Application Reference Number:	2026/0641
--------------------------------------	-----------

Application Type:	Permission in Principle
--------------------------	-------------------------

Proposal Description:	Residential development up to 9 dwellings (Permission in Principle).
Location:	Land off Barnsley Road, Darton, Barnsley

Drawing Title.
**SITE PLAN AS
PROPOSED
9NO DWELLINGS**

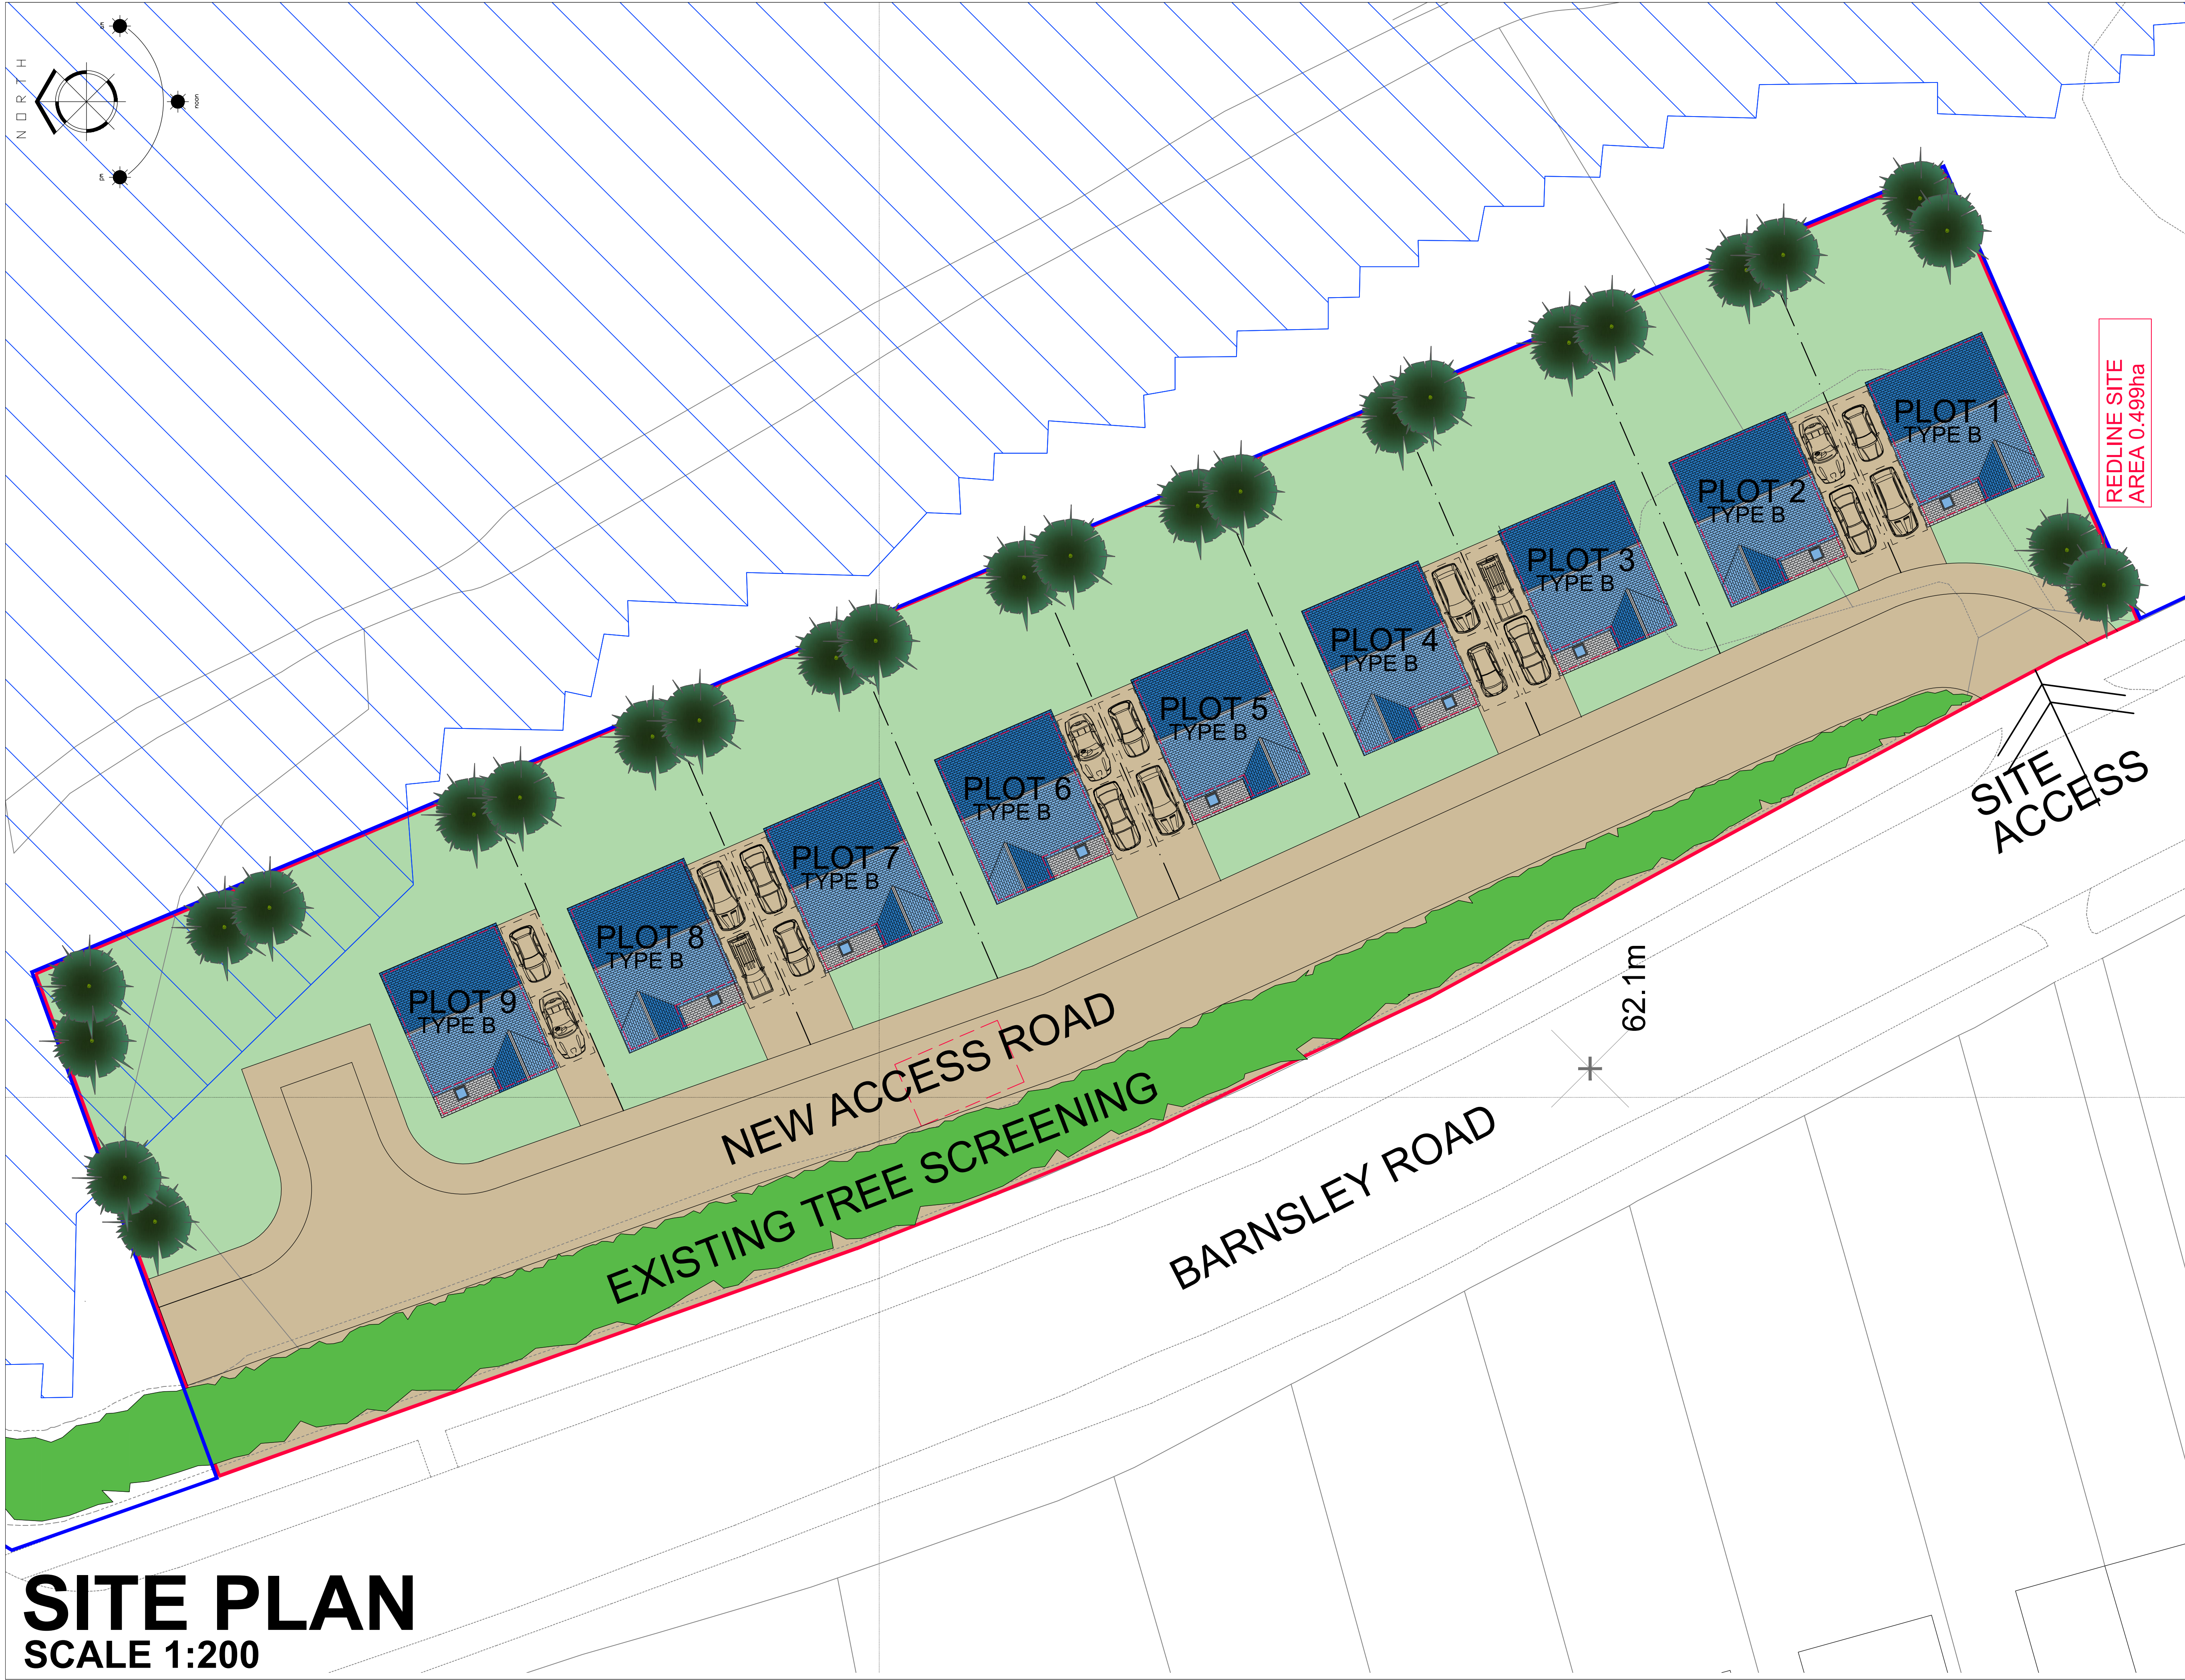
3. The accesses to Plots 1 and 2 are too close to the site access junction with Barnsley Road; there should be no vehicular accesses/driveways within 20m of the junction. Minimum sight lines of 2.4m x 120m are required at the site access junction with Barnsley Road; the sight line to the left (South) appears to be achievable but it is unclear whether the sight line to the right (North) can be achieved. Swept path manoeuvres of an 11m long refuse vehicle would need to be provided in order to demonstrate that the vehicle can manoeuvre in and out of the site access (to/from both directions) and turn within the site.

The layout does not include any visitor parking; two spaces should be provided (1 space per 4 dwellings). It is noted that the red line boundary includes part of the public highway. At the north-western area of the site, it appears that the highway boundary extends around 9m beyond the rear of the footway to a point that would be approximately in the middle of the proposed access road. There is an embankment within the site which acts as a retaining structure for Barnsley Road, as such, any future detailed proposals must include plans and information regarding the proposed levels along the access road and any impact that the development may have upon the embankment. It is worth making clear that the

protection of the retaining embankment is intrinsic to the proposed development being satisfactory from a highways perspective. Given the design, safety, inspection and maintenance considerations involved and the potential impact on highway users it will be required that the technical approval procedures contained within DMRB CG 300 must be adhered to for all highway structures. The approval procedure is to be followed for the construction or alteration of any highway structure, whether to be adopted or not, with The Technical Approving Authority being the Highway Authority. For information, the definition of a highway structure can fall into one of two types, either:

Given the proximity of the supporting structure to Barnsley Road, and that if it were to fail would endanger users, if the applicant intends to, for example, cut into the embankment and erect a retaining wall, there will be a need for the applicant to provide design details including a cross section of the wall for consideration by the structures team before determination of the application and subsequent technical approval through the Approval in principle (AIP) procedure.
